27 January 2012

**Re: Section 75W Modification Application (MP08\_0222 MOD 2) – Global Switch Sydney 2 Data Centre, 273 Pyrmont Street, Ultimo**

drawing title  
**basement level 3  
floor plan**

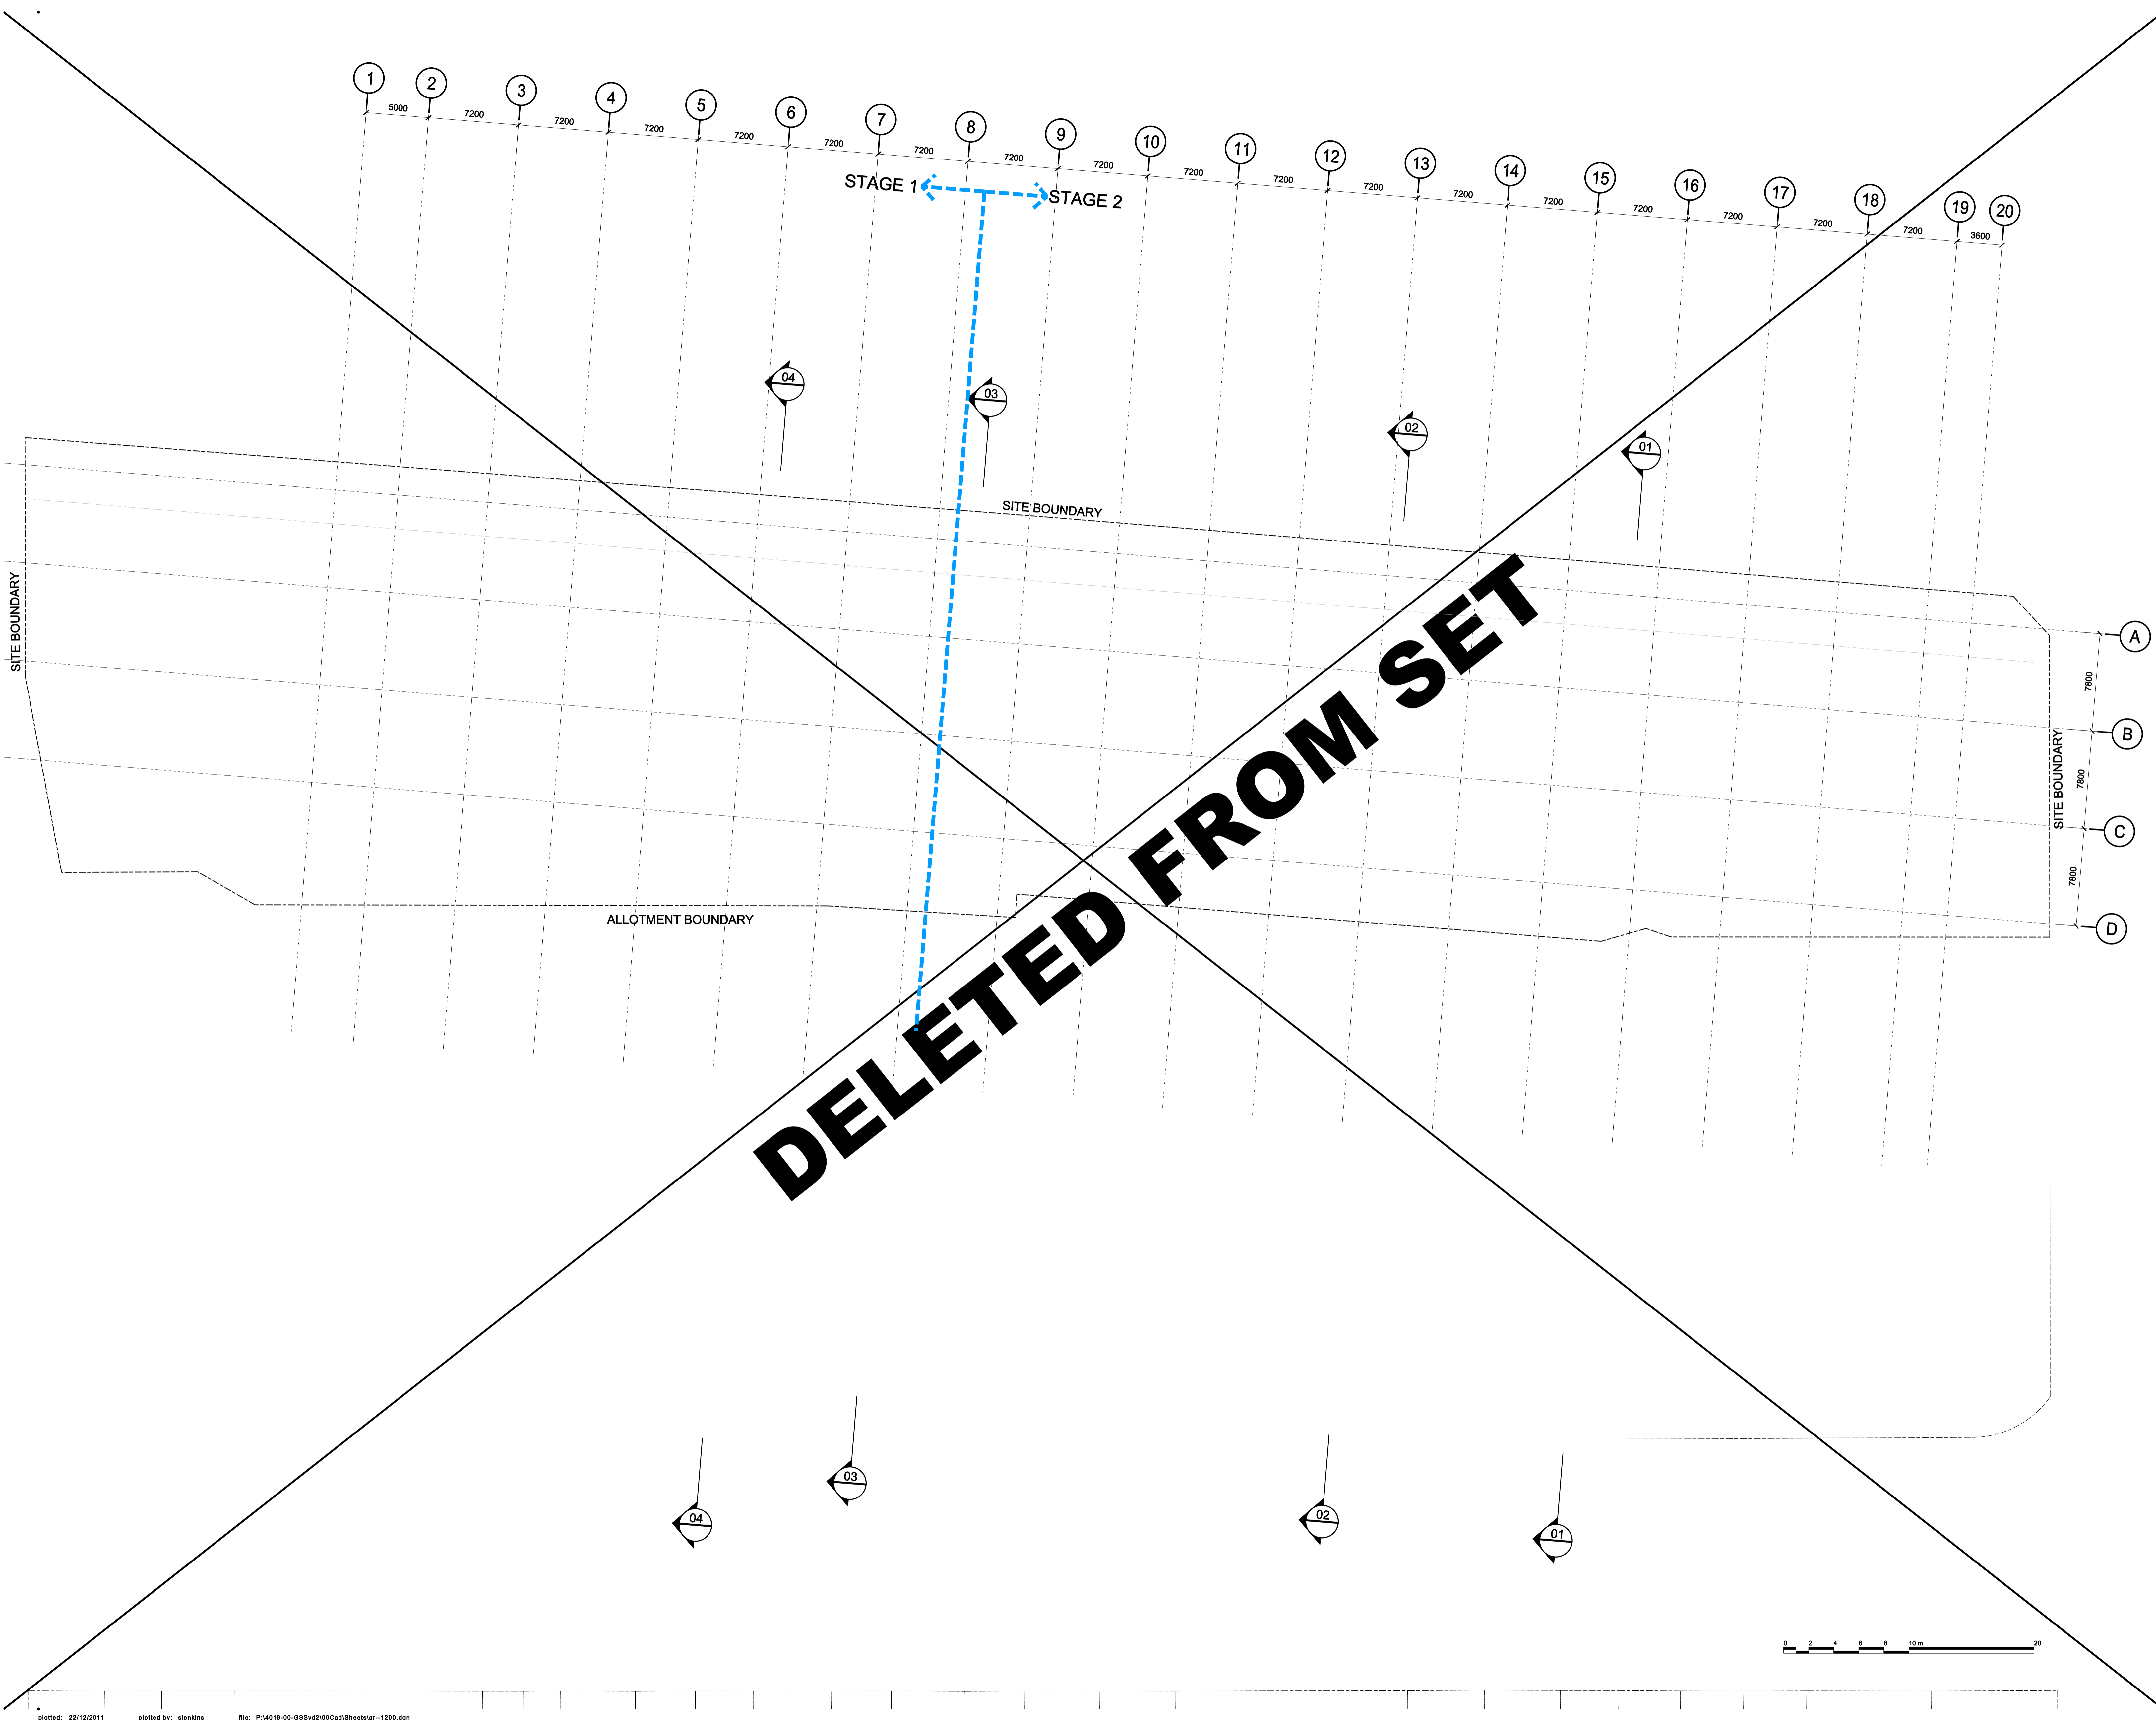
I have perused the architectural drawings on the NSW Planning & Infrastructure website in regards to this proposed development ([http://majorprojects.planning.nsw.gov.au/index.pl?action=view\\_job&job\\_id=5128](http://majorprojects.planning.nsw.gov.au/index.pl?action=view_job&job_id=5128)) and it appears as though the basement and ground level of the proposed development extend to the site boundary on the Pyrmont Street side.

- Ausgrid owns electrical infrastructure located within the premises being developed that will be affected by this proposal. Among these assets are in service high voltage and pilot cables.
- There are additional high voltage and pilot cables located in the footpath and the roadway surrounding the site that may be affected by the proposed building and/or construction activity.
- From the architectural drawings it appears that the 33kV customer substation S.7988 HARRIS QUARY (which is located in EXISTING GLOBAL SWITCH 1) will not be affected.

Further discussions will be required to determine how many affected assets will need to be relocated. Information on the relocation of assets process can be found on Ausgrid's website where there is a list of applicable documents and guidelines.  
<http://www.ausgrid.com.au/Common/Our-network/Standards-and-Guidelines/Electrical-supply-standards.aspx>
